RE: ENGINEER CERTIFICATION FOR MALOOF TRUCKING STATION (J14-D124)
CERTIFICATION STATEMENT DATED 2/3/98

RE: DRAINAGE PLAN FOR MALOOF TRUCKING STATION (J14-D124) ENGINEER'S
STAMP DATED 6/10/97

RE: DRAINAGE PLAN FOR MALOOF TRUCKING STATION (J14-D124) ENGINEER'S
STAMP DATED 6/10/97

MALOOF TRUCKING STATION
GRADING & DRAINAGE PLAN

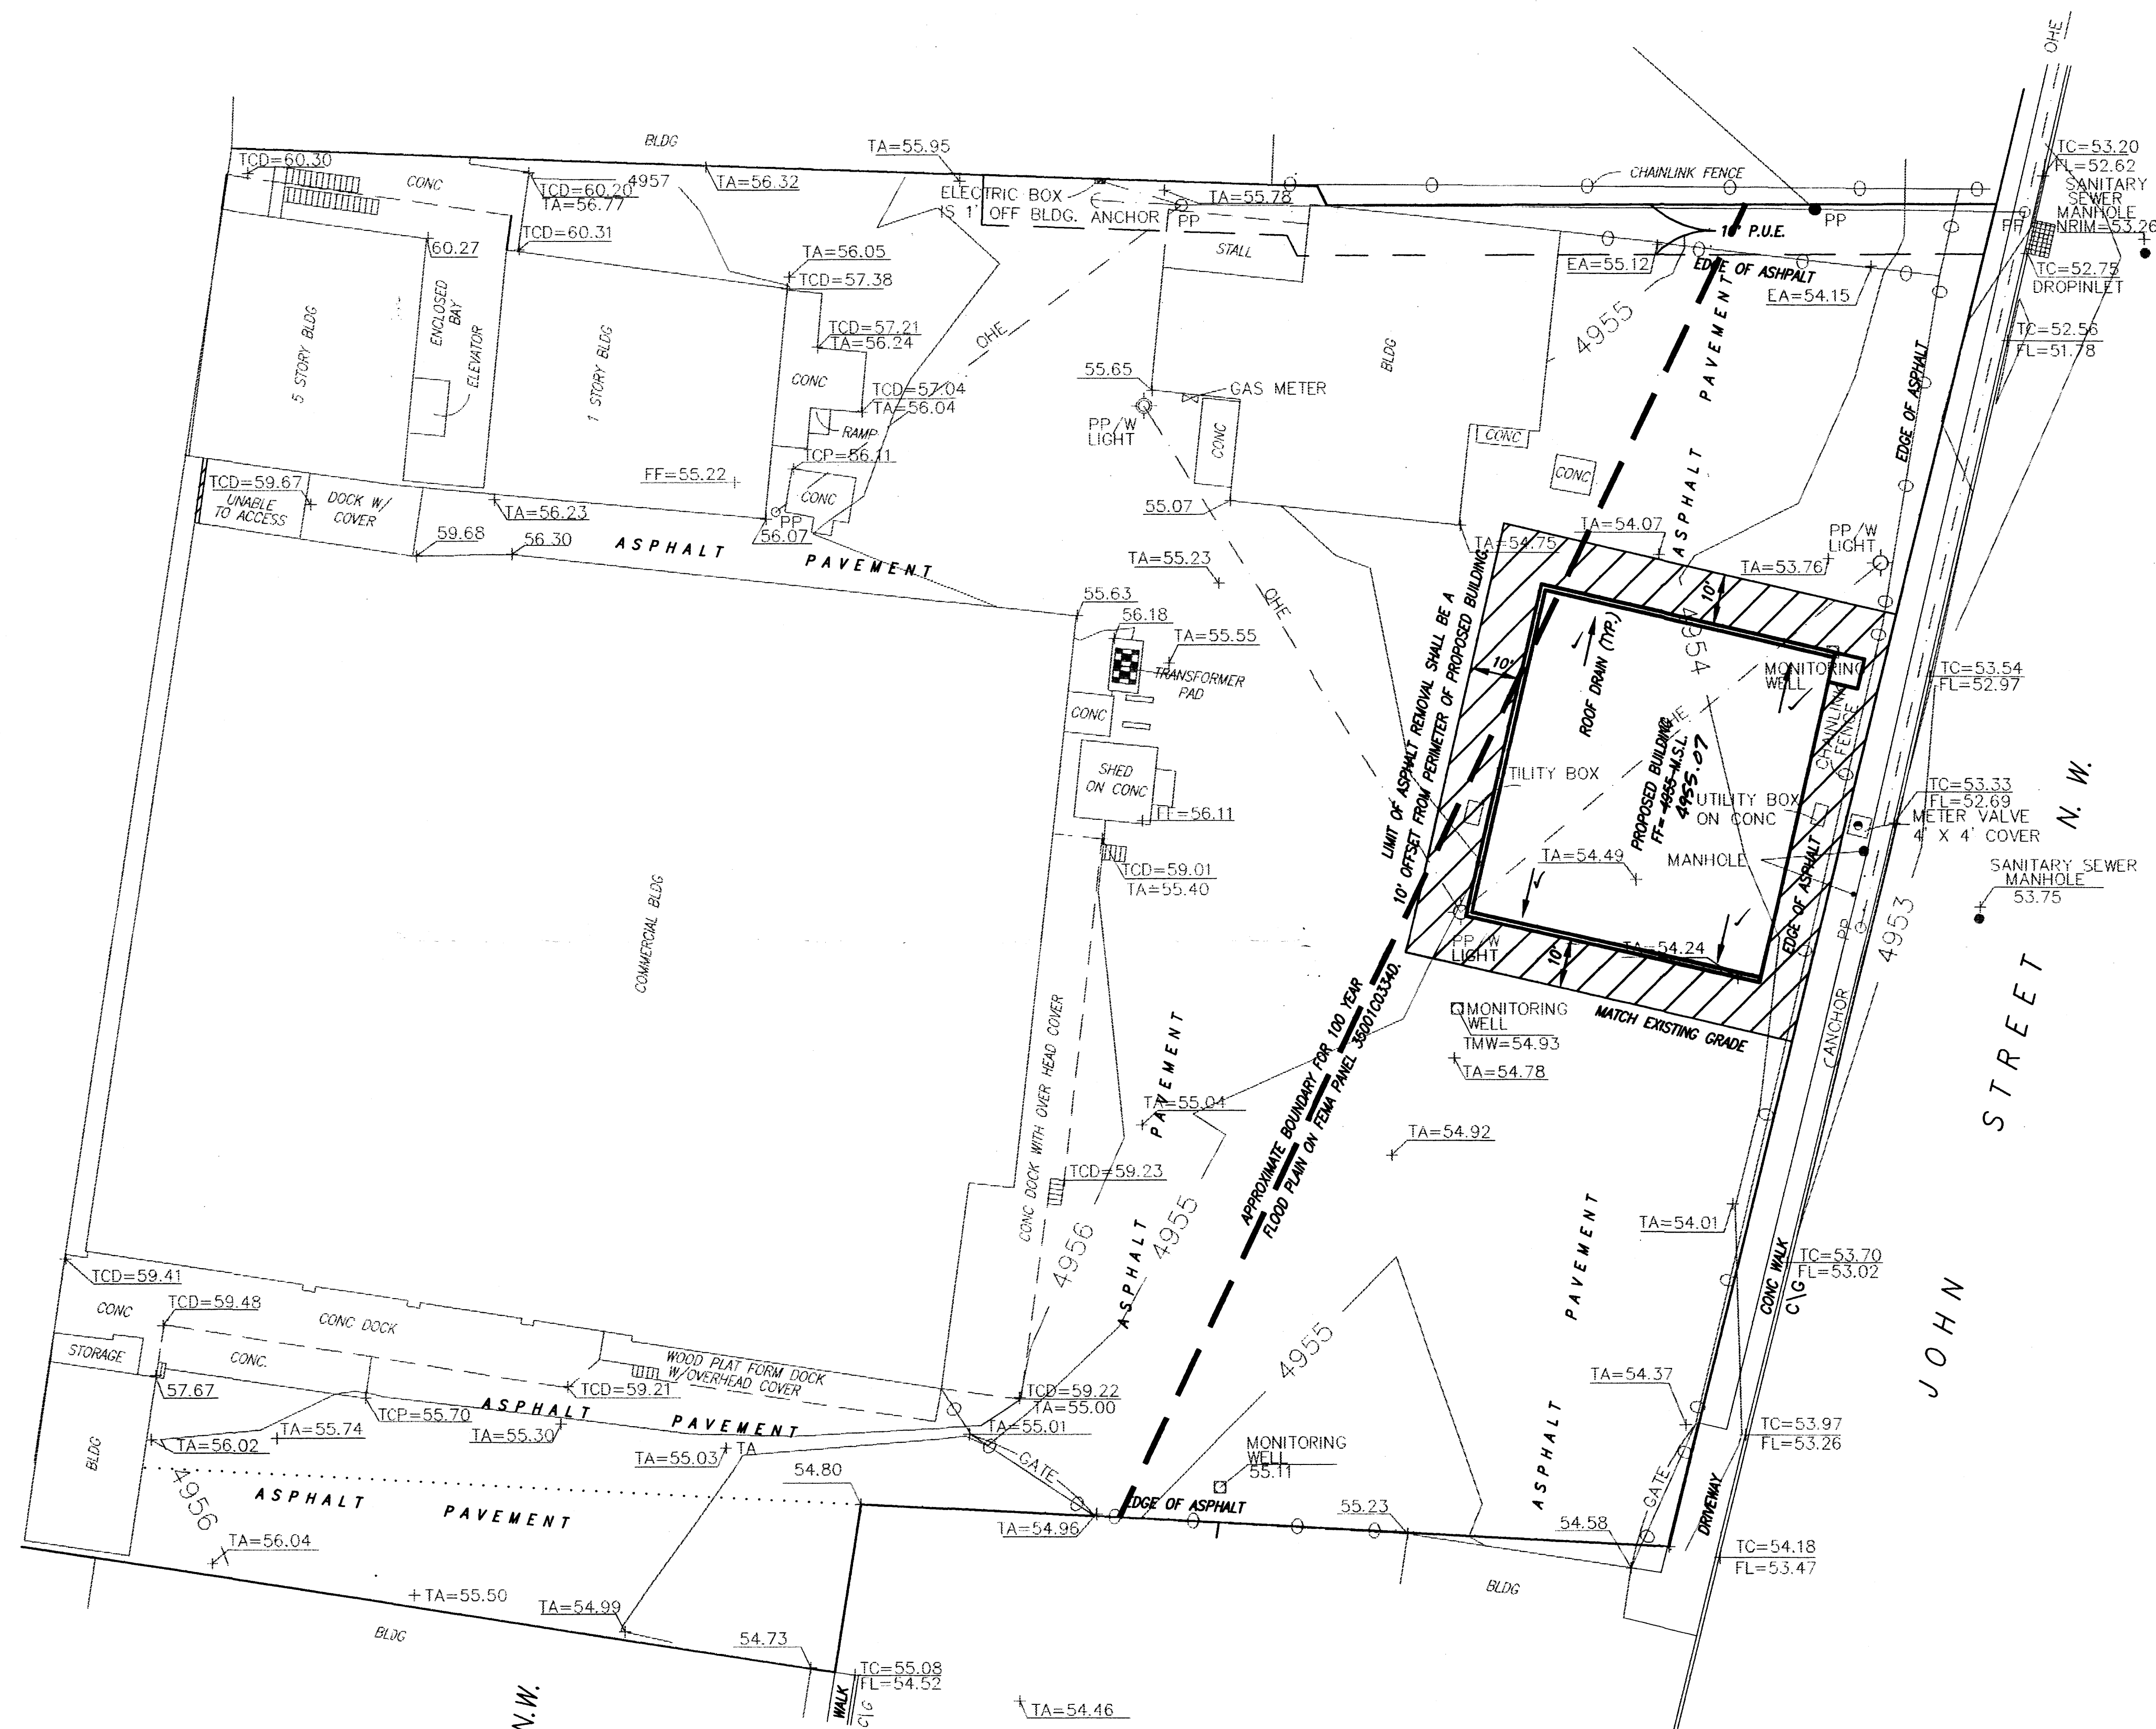
Based on the information provided on your July 25, 1997 submittal, we will need the complete area shown on the drainage plan including the calculations. Research of our files has determined that no plan exists for the overall site, therefore a submittal which includes the proposed addition must be submitted.

needs Engineer
Calcs

Also, prior to any further development, as stated on the correspondence from the Maloof Companies, an overall management drainage plan will be submitted for review and approval.
